Case Officer: Caroline Ford

Applicant: Barton Willmore LLP on behalf of A2 Dominion

Proposal: Full permission is sought for Local Centre Community Floorspace (Use Class D1 with ancillary A1/A3), with a total GIA of 552 sqm, and 16 residential units (Use Class C3) with associated access, servicing, landscaping and parking. Outline consent is sought for Local Centre Retail, Community or Commercial Floorspace (flexible Use Class A1/A2/A3/A4/A5/B1/D1).

RECOMMENDATION: GRANT PERMISSION SUBJECT TO CONDITIONS AND SUBJECT TO A S106 LEGAL AGREEMENT

# APPENDIX A – Proposed Site Layout

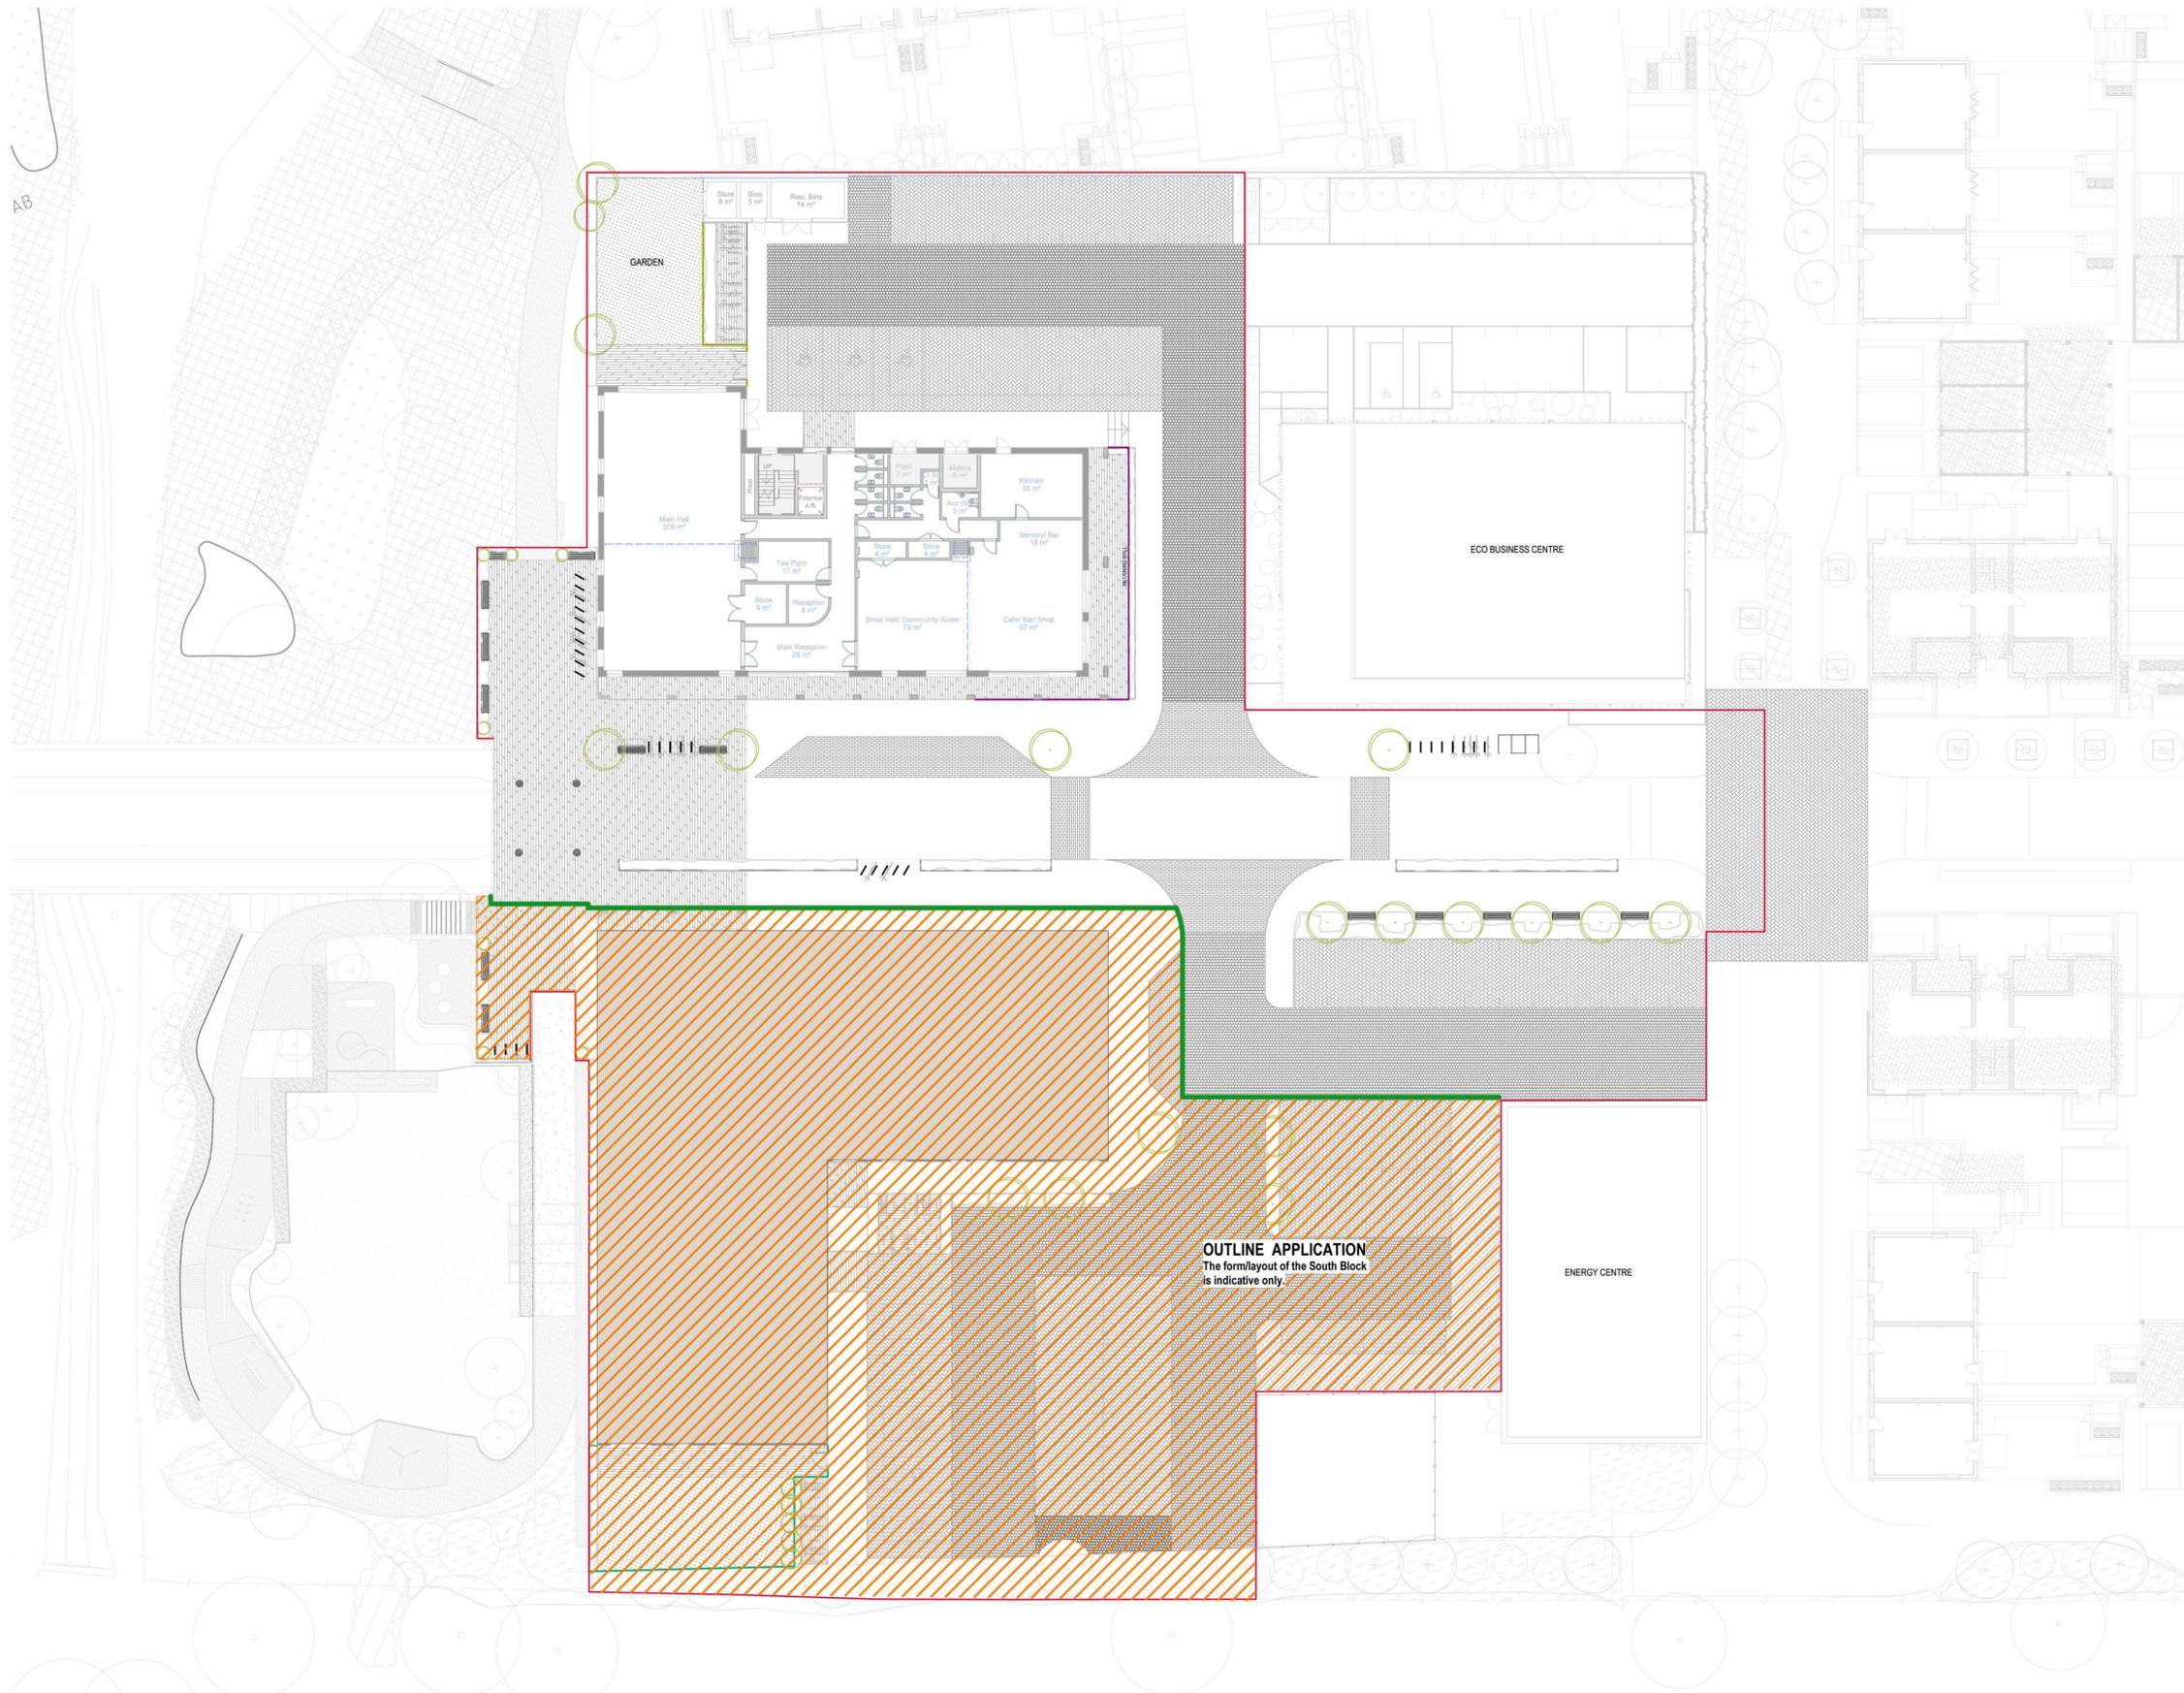
- 7.6. OCC HIGHWAYS (second response to amended scheme): No objection subject to conditions. The following points are made:
- Unsatisfactory refuse vehicle tracking drawings have been submitted for the northern block which appears to show that access to bin storage is not possible except when utilising land outside of the application boundary.

- The provided tracking diagrams show that an 11.7m refuse vehicle would be able to manoeuvre in and out of the site but there is a concern that it cannot safely get to the bin storage proposed. The manoeuvring required would need part of the Eco Business Centre car park and egress is also likely to be more difficult. An arrangement with the Eco Business Centre will be required otherwise the arrangement for refuse and service deliveries to the northern block would not be possible.
